Rezoning Transportation Analysis
Petition Number: Insert Zoning Petition #2021-015
General Location Identifier: 11504601, 11504613

Revision Log:

Date	Description
02-25-2021	First Review (KP)

**SKETCH PLAN PRIVATE ALLEY OPTION**

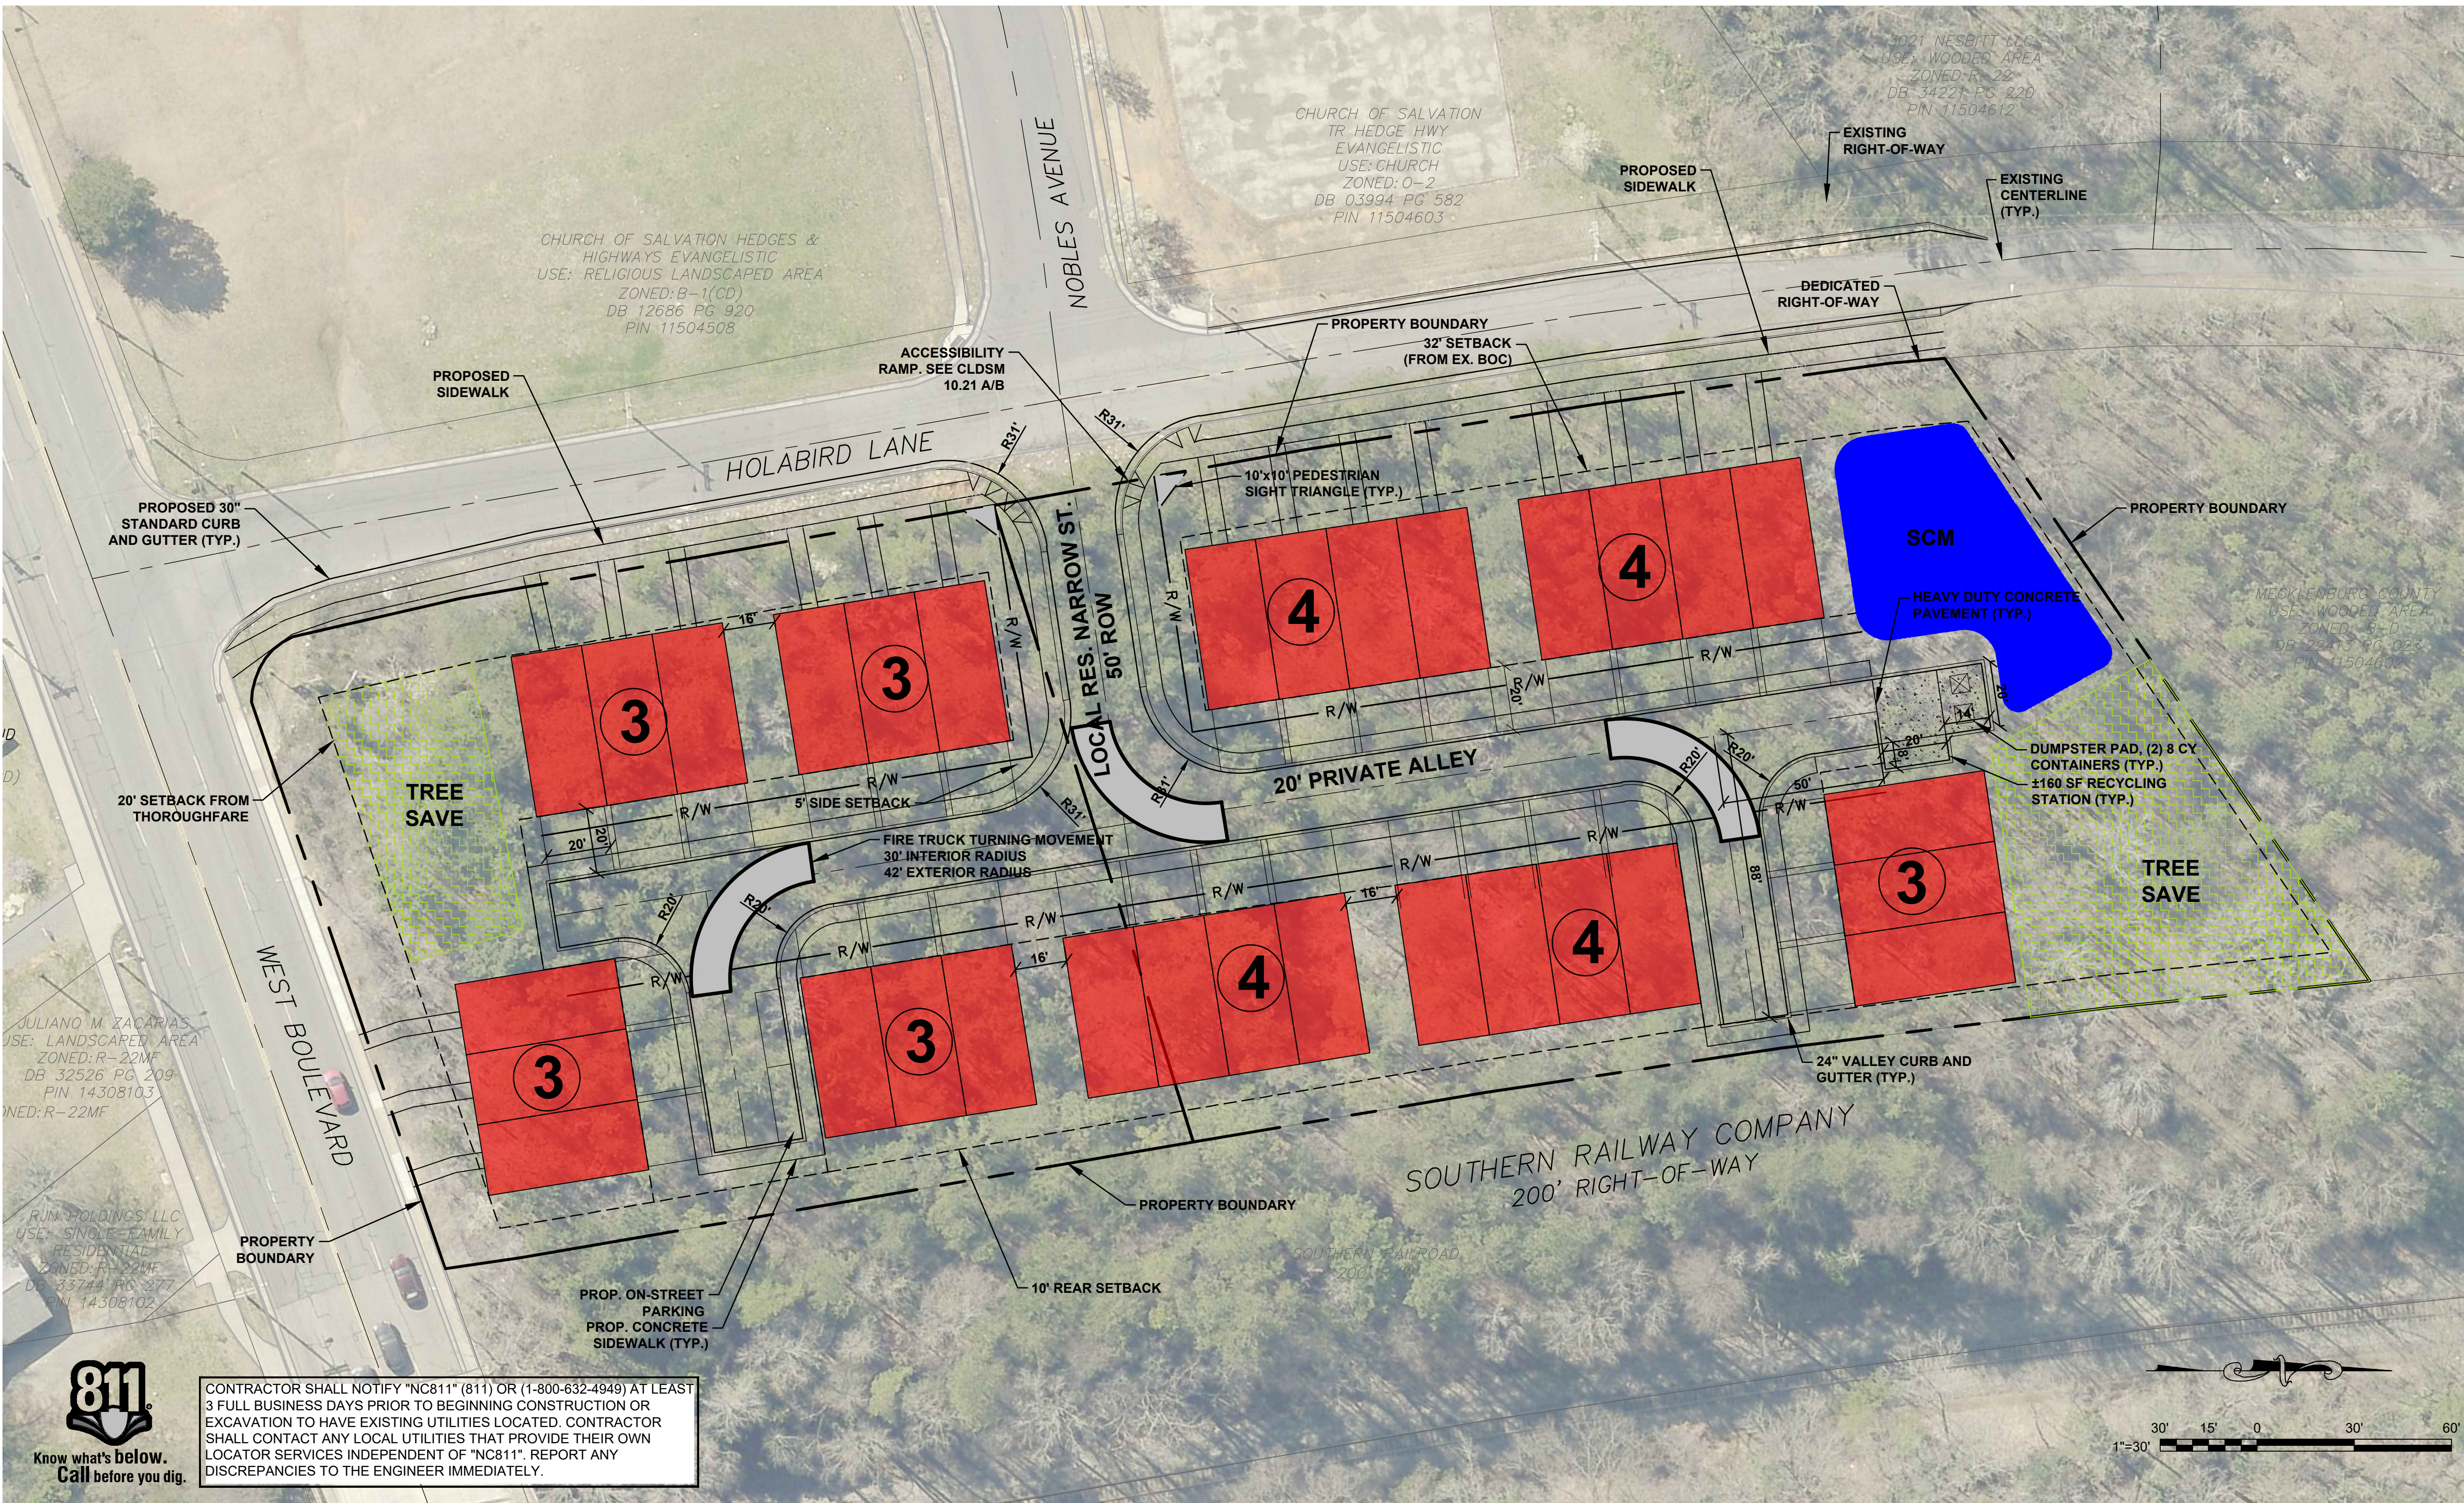
- a. **West Boulevard:** The future curb line for West Boulevard will be 32.5-feet from the existing road centerline to back-of-curb.
- b. **Holabird Lane:** The petitioner will construct the curb 17.5-feet from the existing road centerline to the back-of-curb.

Revise the site plan by labeling and dimensioning the back-of-curb from the centerline of each road.

- a. **West Boulevard:** Revise the site plan and conditional notes by dedicating 50.5-feet of right-of-way from the existing road centerline.
- b. **Holabird Lane:** Revise the site plan and conditional notes by dedicating 35.5-feet of right-of-way from the existing road centerline.

Label and dimension the right-of-way from the centerline of each road.

4. Per Chapter 19 and Chapter 20, revise the site plan and conditional notes by committing to the construction of an 8-foot planting strip and 6-foot sidewalk along the site’s Holabird Lane frontage. Additionally, construct an 8-foot planting strip and 8-foot sidewalk, along the site’s West Boulevard frontage, relative to the future back-of-curb location.

Label and dimension each item from the centerline of each road.

5. Revise the site plan and conditional notes by constructing an 8-foot buffered bike lane, 3-foot buffer with 5-foot travel lane, along the site’s West Boulevard frontage.

Label and dimension from the centerline of West Boulevard.

6. Revise the site plan and conditional notes to commit to construct on-street parking along the site’s Holabird Lane frontage. This on-street parking will be constructed in accordance with CLDSM Details 50.09C and 50.09D.

7. Revise the site plan and conditional notes by committing to extending the 8-foot planting strip and 6-foot sidewalk, along Holabird Lane, to the existing sidewalk at the cul-de-sac of Holabird Lane. This sidewalk will provide a pedestrian connection from West Boulevard to the Southwest Recreation Center where a gap currently exists and would assist CDOT in finishing an important pedestrian connection.

8. Revise the site plan and conditional notes by committing to the replacement of the ADA compliant curb ramps at the intersection of West Boulevard and Holabird Lane.

9. A site plan note(s) specifying dedication and fee simple conveyance of all rights-of-way to the City before the site's first building certificate of occupancy is issued is needed. CDOT requests rights-of-way set at 2' behind back of sidewalk where feasible.

A site plan note specifying that all transportation improvements will be approved and constructed before the site's first building certificate of occupancy is issued is needed. The petitioner may phase transportation improvements if said improvements and phasing are explicitly described in site plan notes.
